PERSIMMON HOMES
NORTH LITTLEHAMPTON PHASE 2
B3/B5 ACCESS ROAD

STAGE 1 SAFETY AUDIT - ADDENDUM

Project Code:	S/PHLITTLE-P2.1B.6a
Prepared by:	Ken Fry
Approved by:	John Reid
Issue Date:	29 April 2016
Status:	FINAL

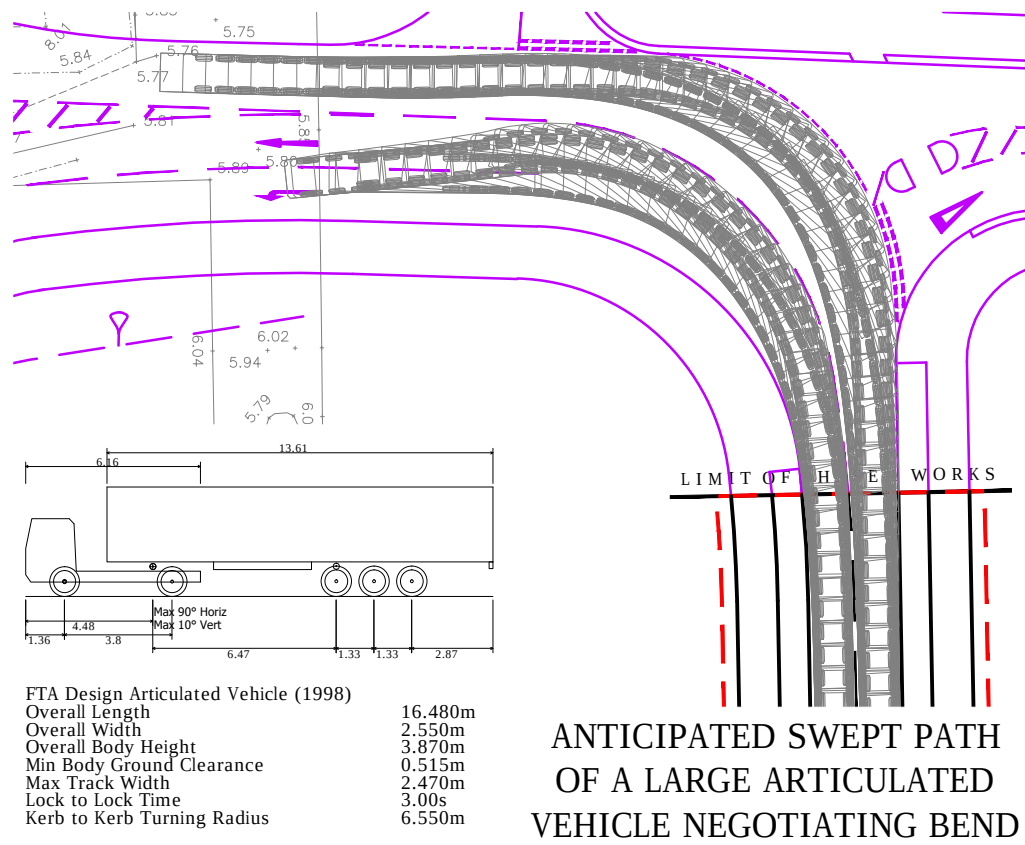
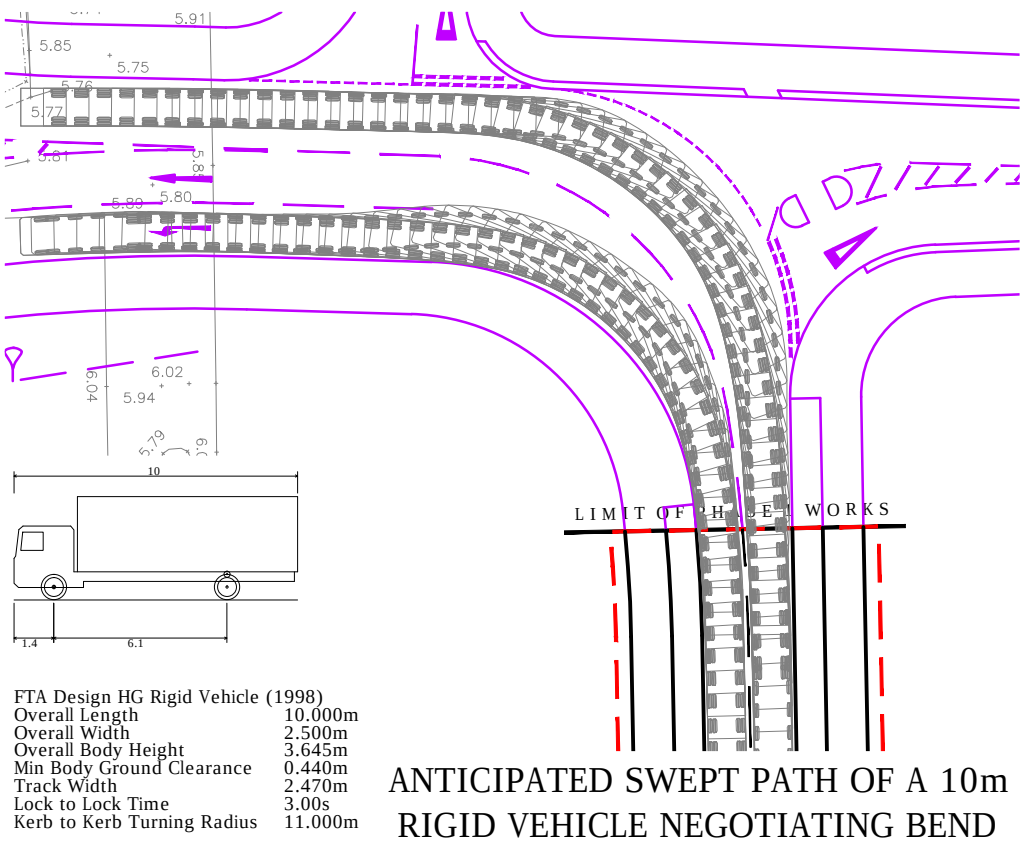
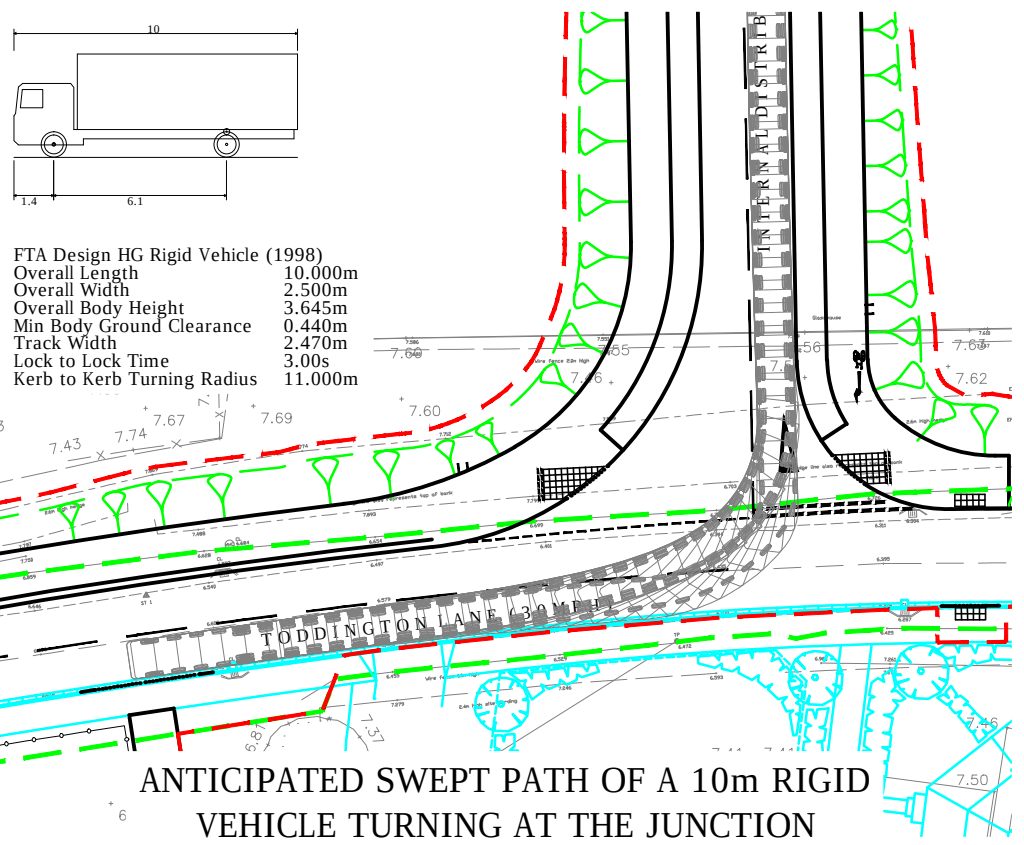
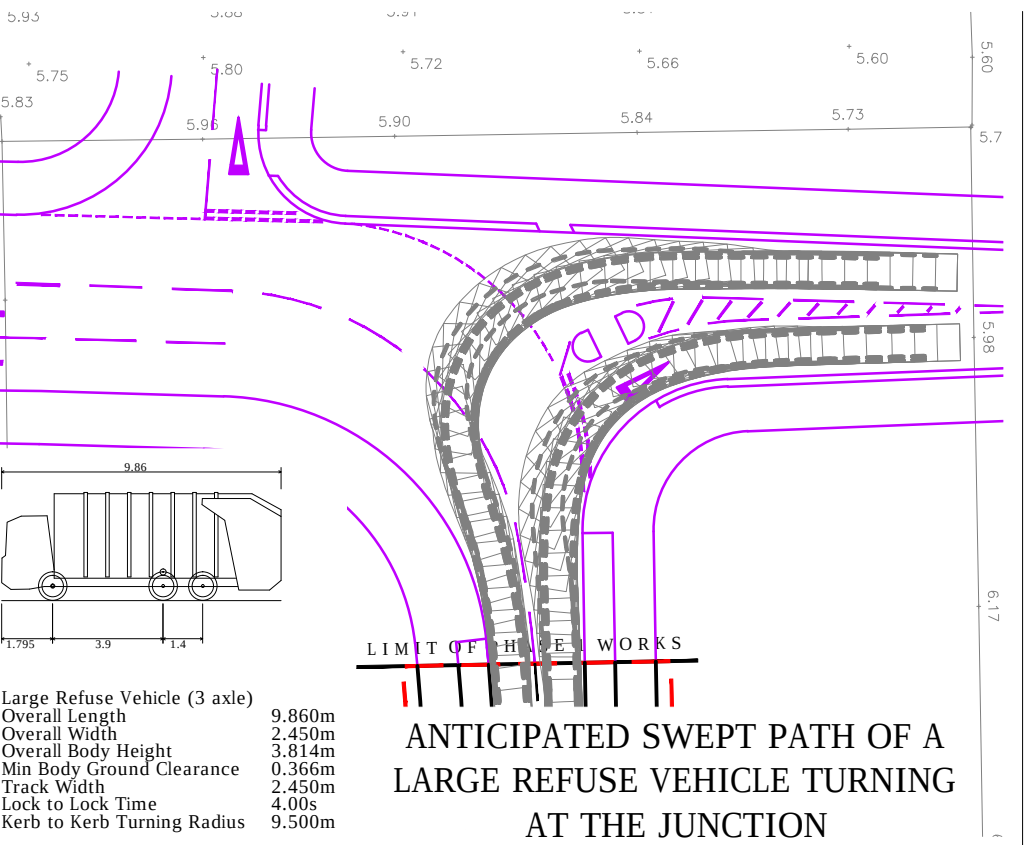
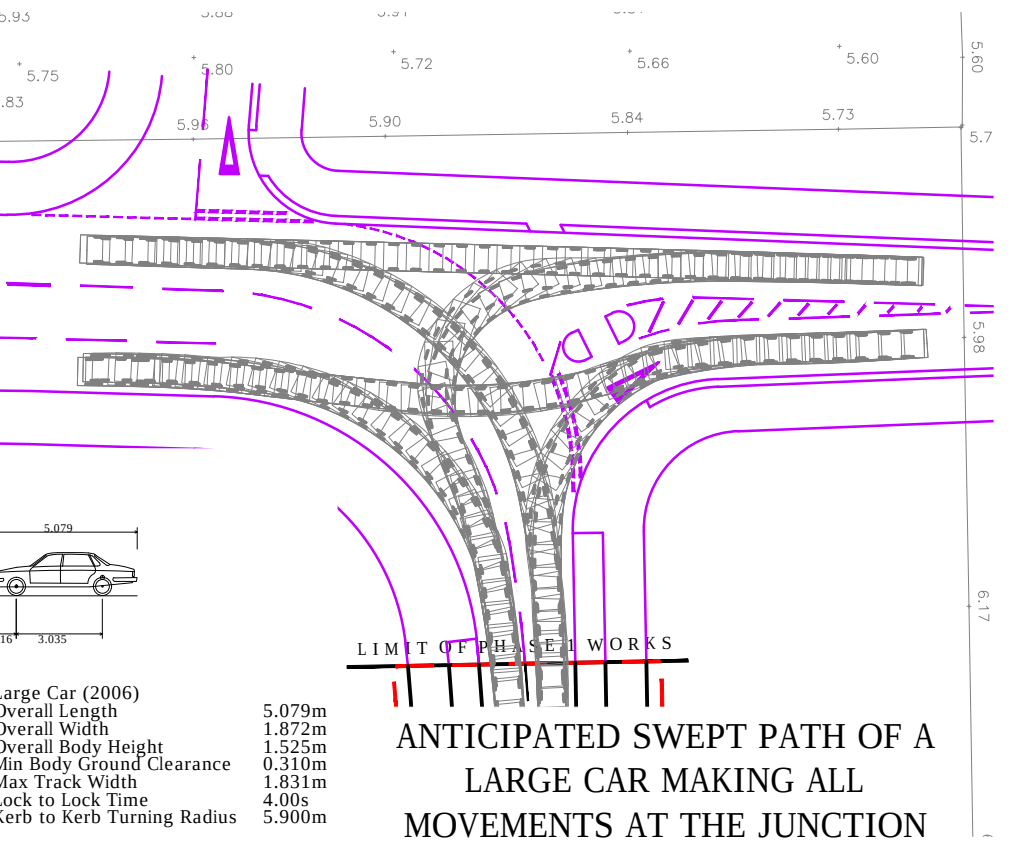
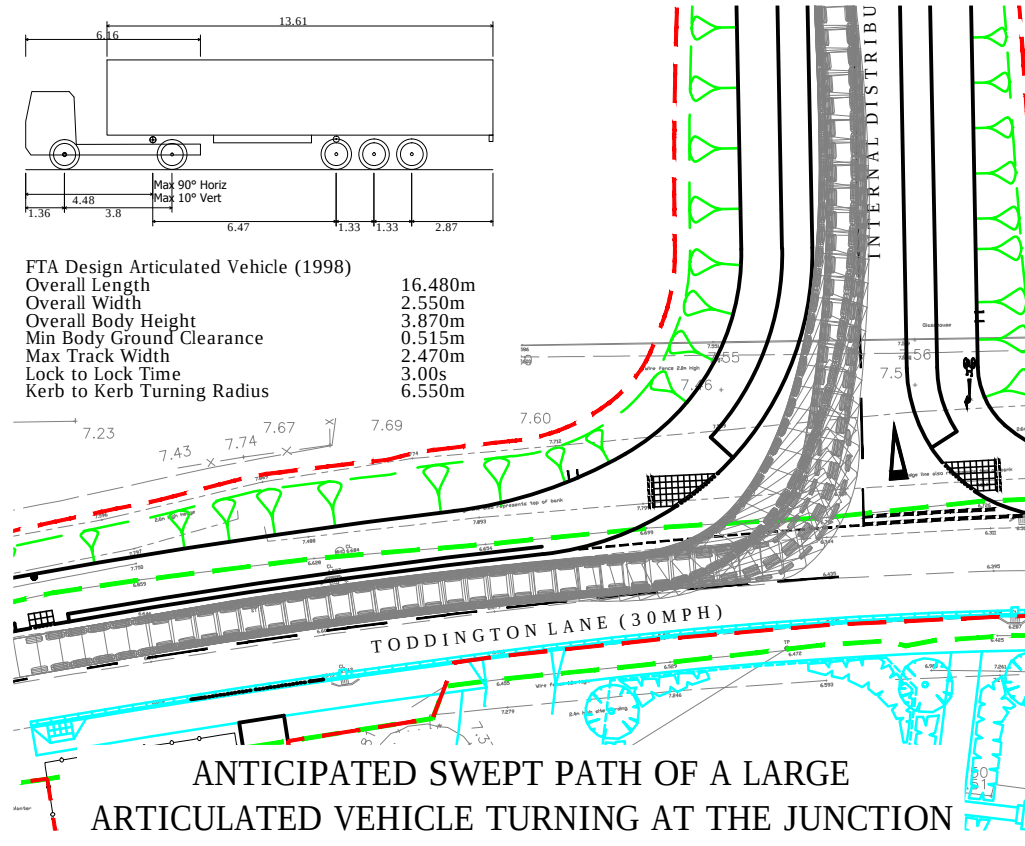
The drawing shows a 20m kerb radius on the west side of the junction. This could encourage relatively high speeds by left-turning vehicles, particularly cars and light vans, and it increases the width of carriageway to be traversed by pedestrians crossing the junction; both of these factors increase the danger to pedestrians from turning vehicles. Whilst it appears from the traffic flow information supplied in the Audit Brief that a significant number of HGVs will use this junction, it is clear from the swept path plots that the radius could be reduced without causing them difficulty.

- i. Reduce the kerb radius as far as possible consistent with providing adequate turning space for the largest vehicles regularly using the junction.

- ii. Inset the pedestrian crossing point slightly further into the junction (c.1.5m) to reduce the crossing width for pedestrians, particularly those with a disability, and increase their visibility to/from southbound vehicles approaching on the IDR.
